# CITY OF PORTLAND, MAINE

## HISTORIC PRESERVATION BOARD

June 15, 2012

Re: Construction of Rear Addition; 15 Chadwick Street

FRONT ELEVATION

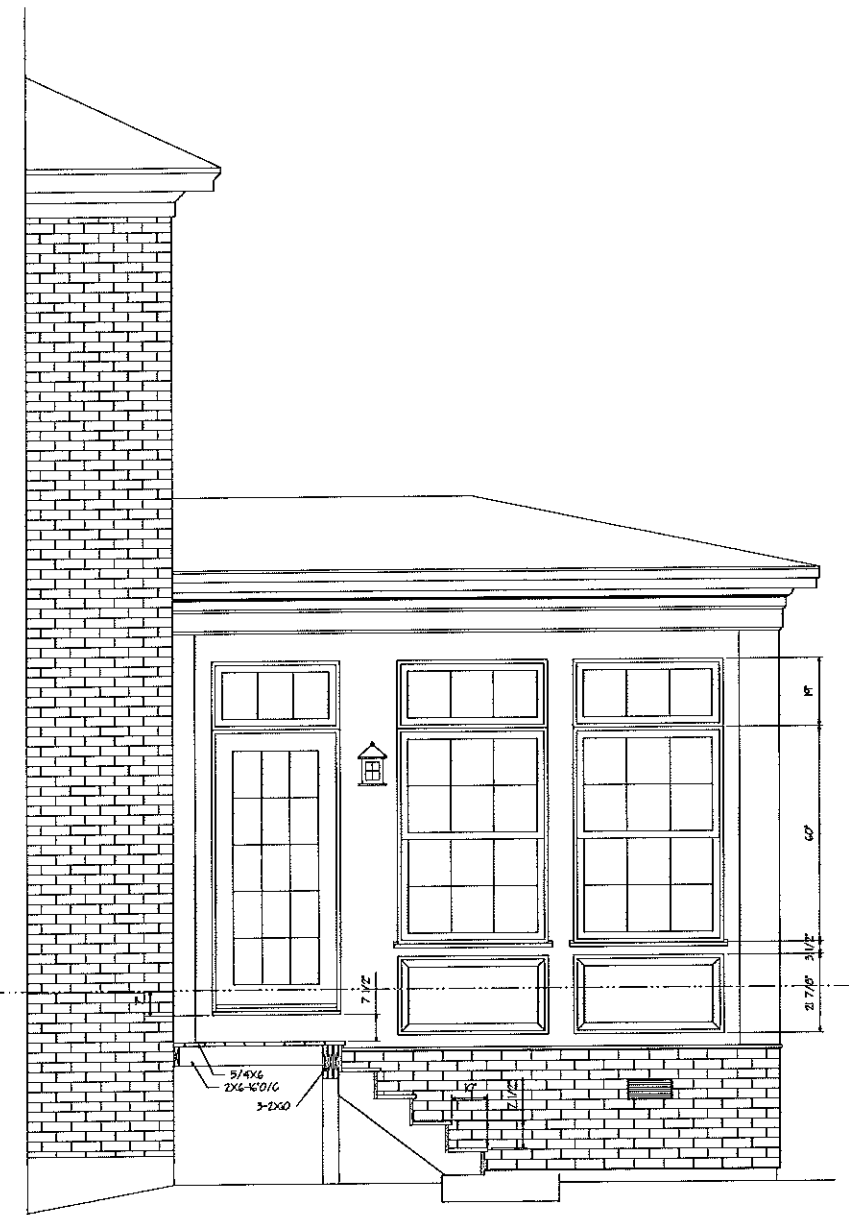
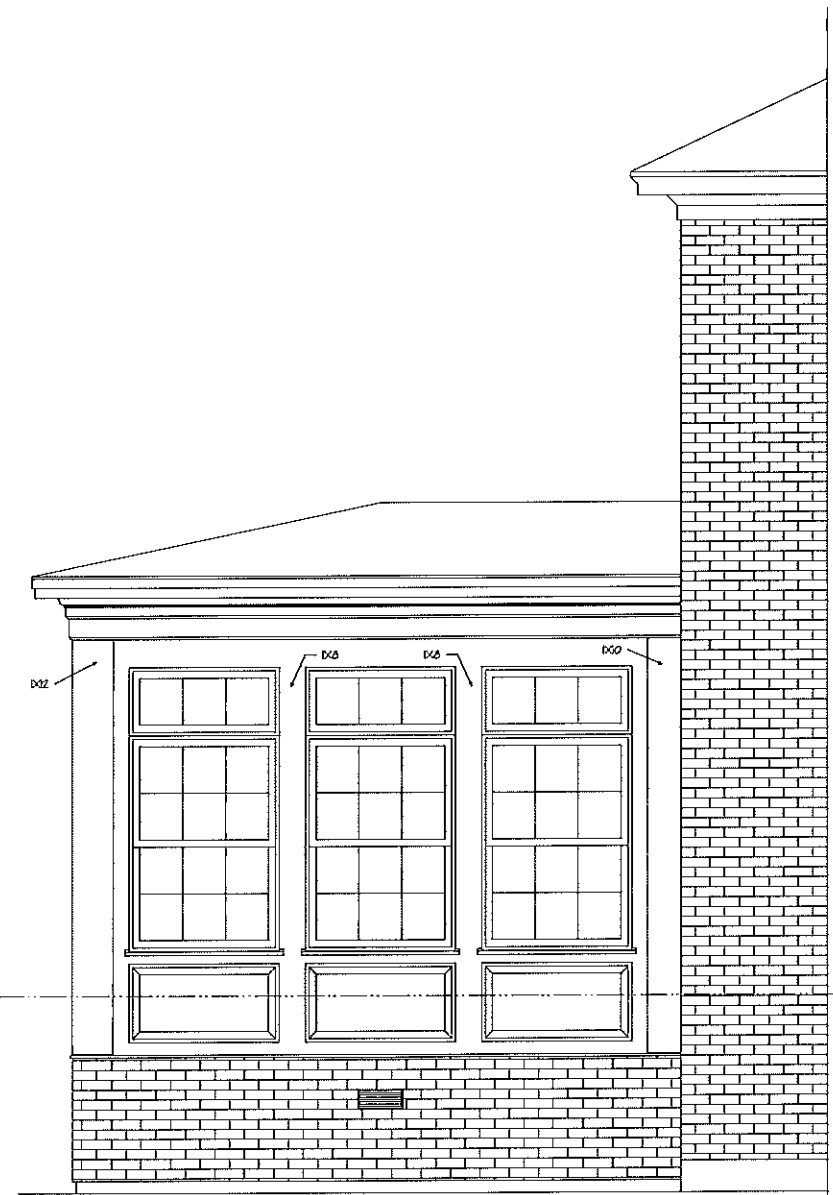
- Brick selection, as well as color, profile and composition of mortar to be reviewed and approved by staff.
- Completion of the brick veneer on the foundation will be executed as marked up during the meeting.
- Window specification to be revised as follows: color of windows to match existing house; screens to be half screens; windows to have VTR of .7 or above.
- Flashing to be counter flashing as opposed to simple flashing.
- Roofline of addition and flashing to be laid out for review prior to installation in order to avoid encroachment on 2<sup>nd</sup> story window of main house.
